Harnett County Government Complex
307 W. Cornelius Harnett Boulevard
Lillington, NC 27546

October 21st, 2024

Re: Status of Permit Application-EH2410-0006

**"PLOT PLAN FOR"**  
**Douglas Clark & Kathy R. Johnson**  
**PARCEL B, MAP #2024-520**

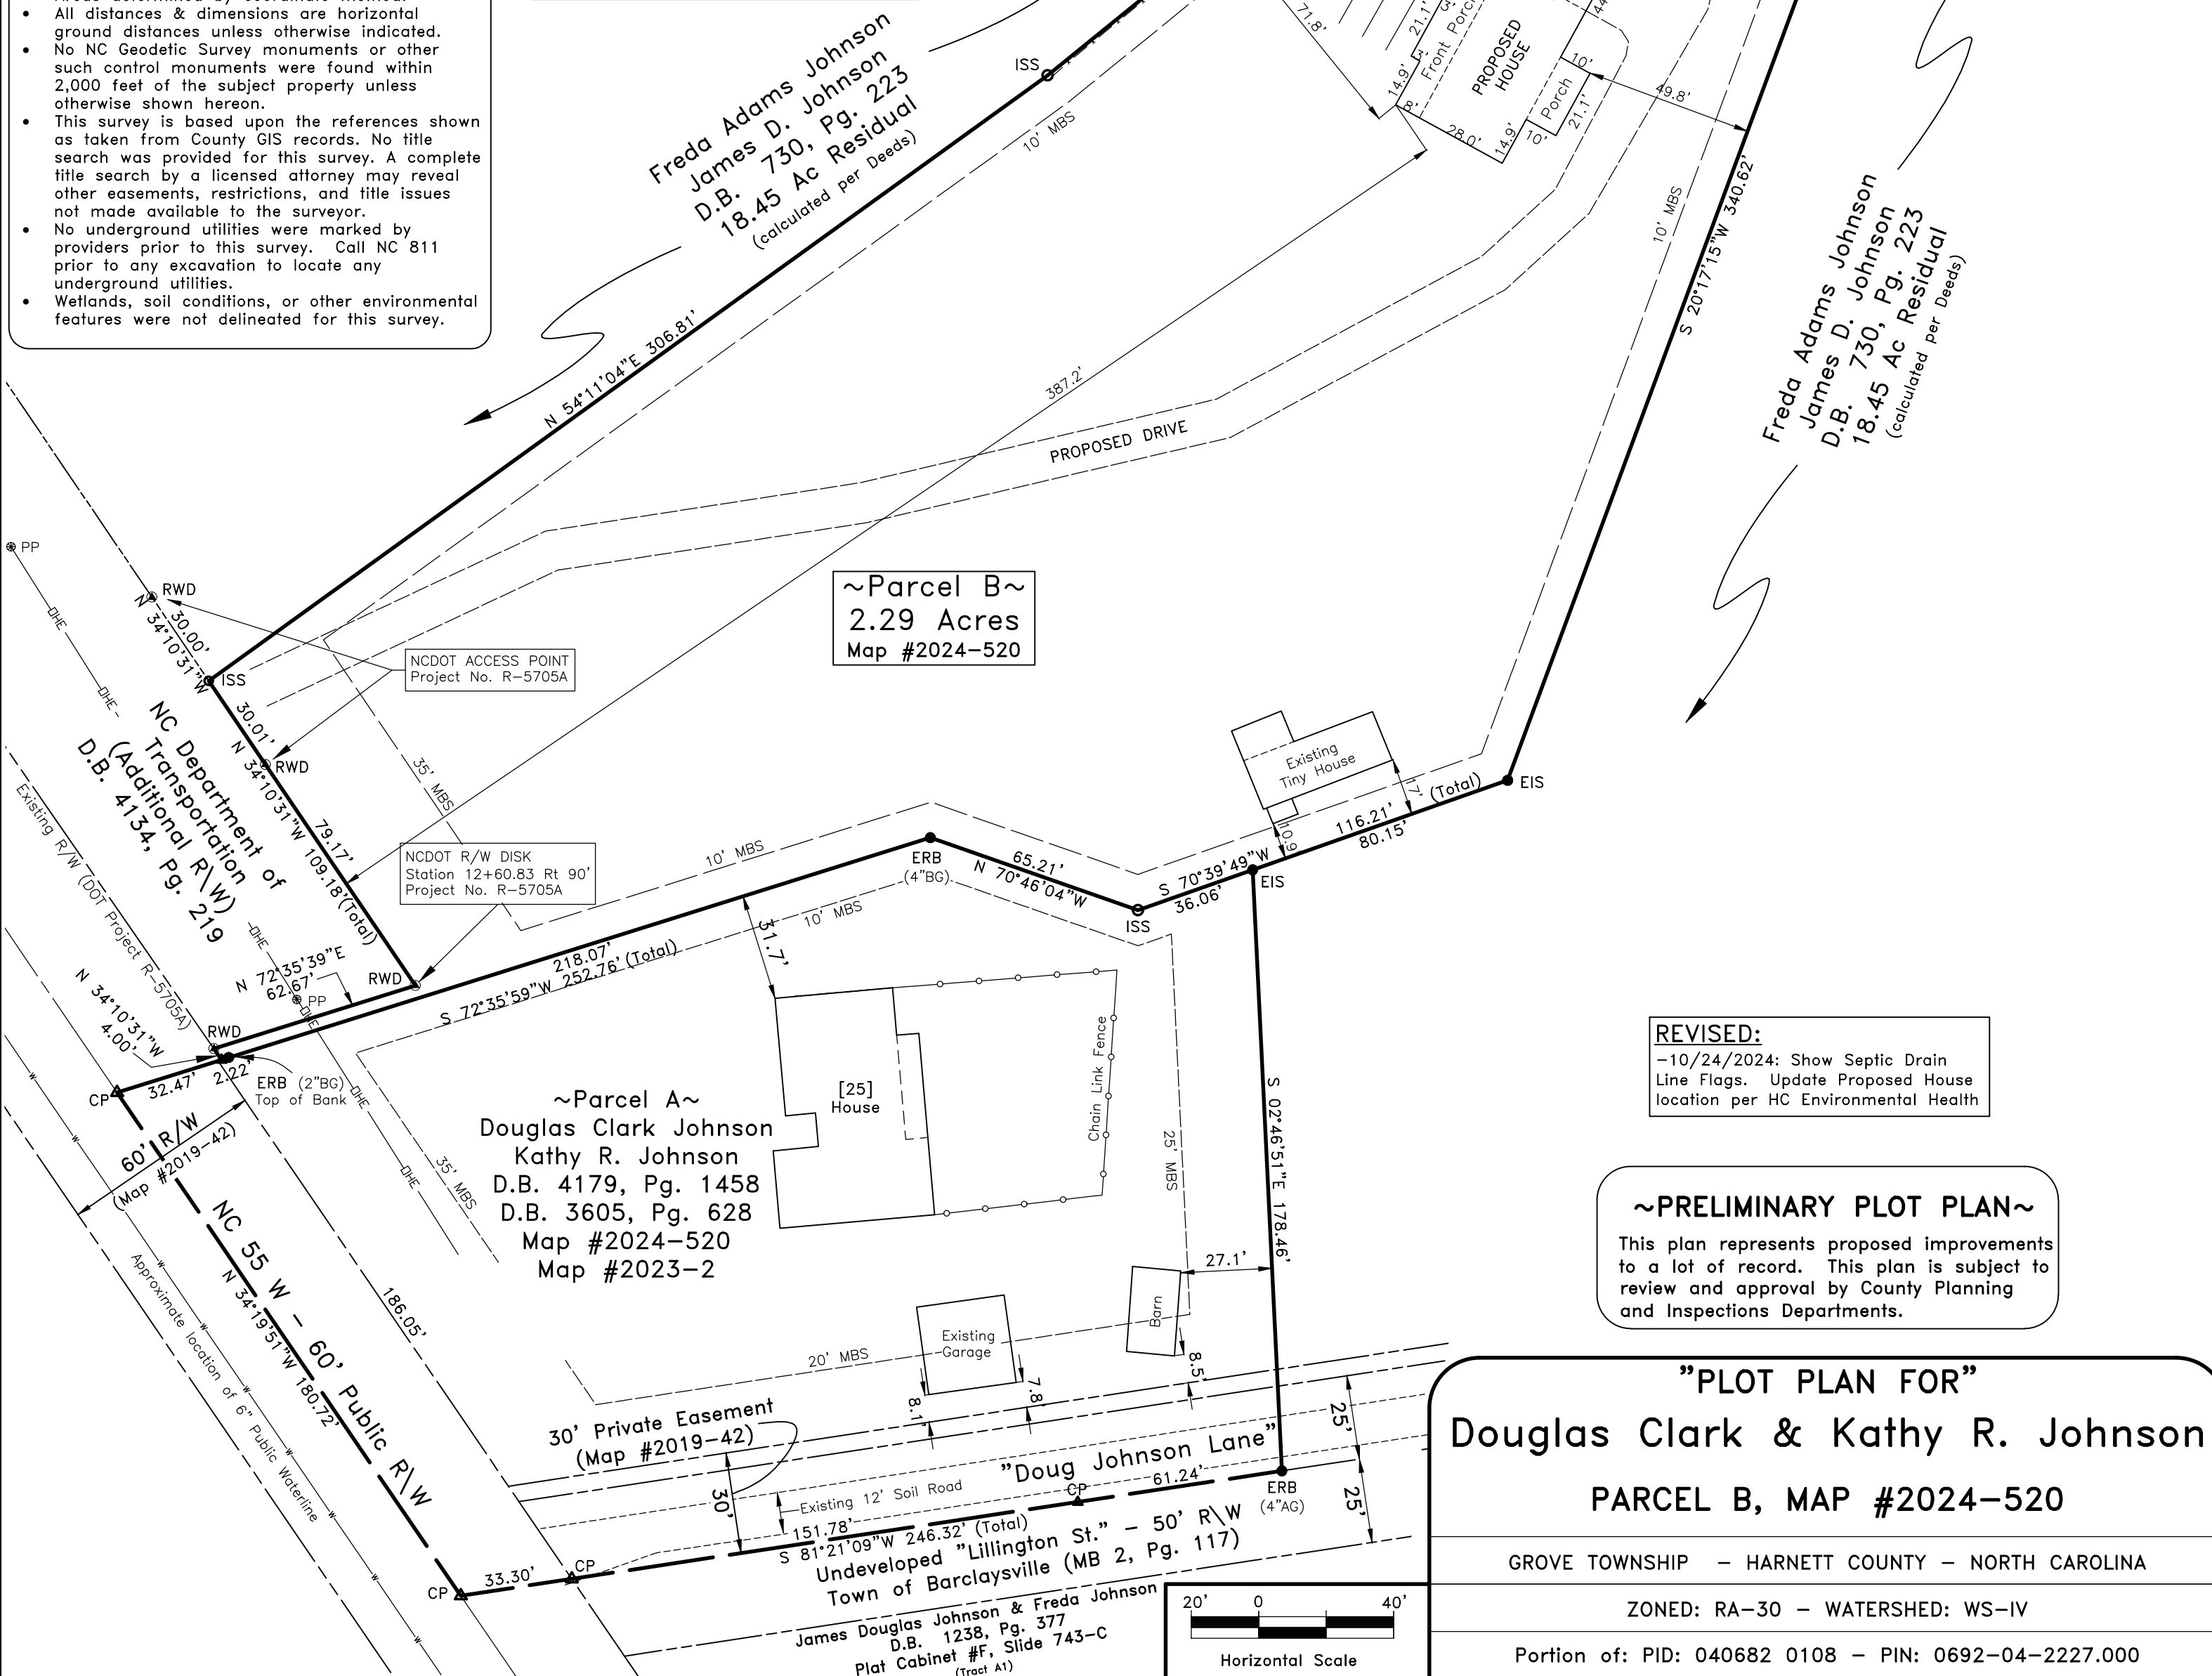
X 7. Other- House box needs to be rotated and uphill slightly to be 5' off the Environmental Health flags. Site plan must be updated with new house box location and setbacks.
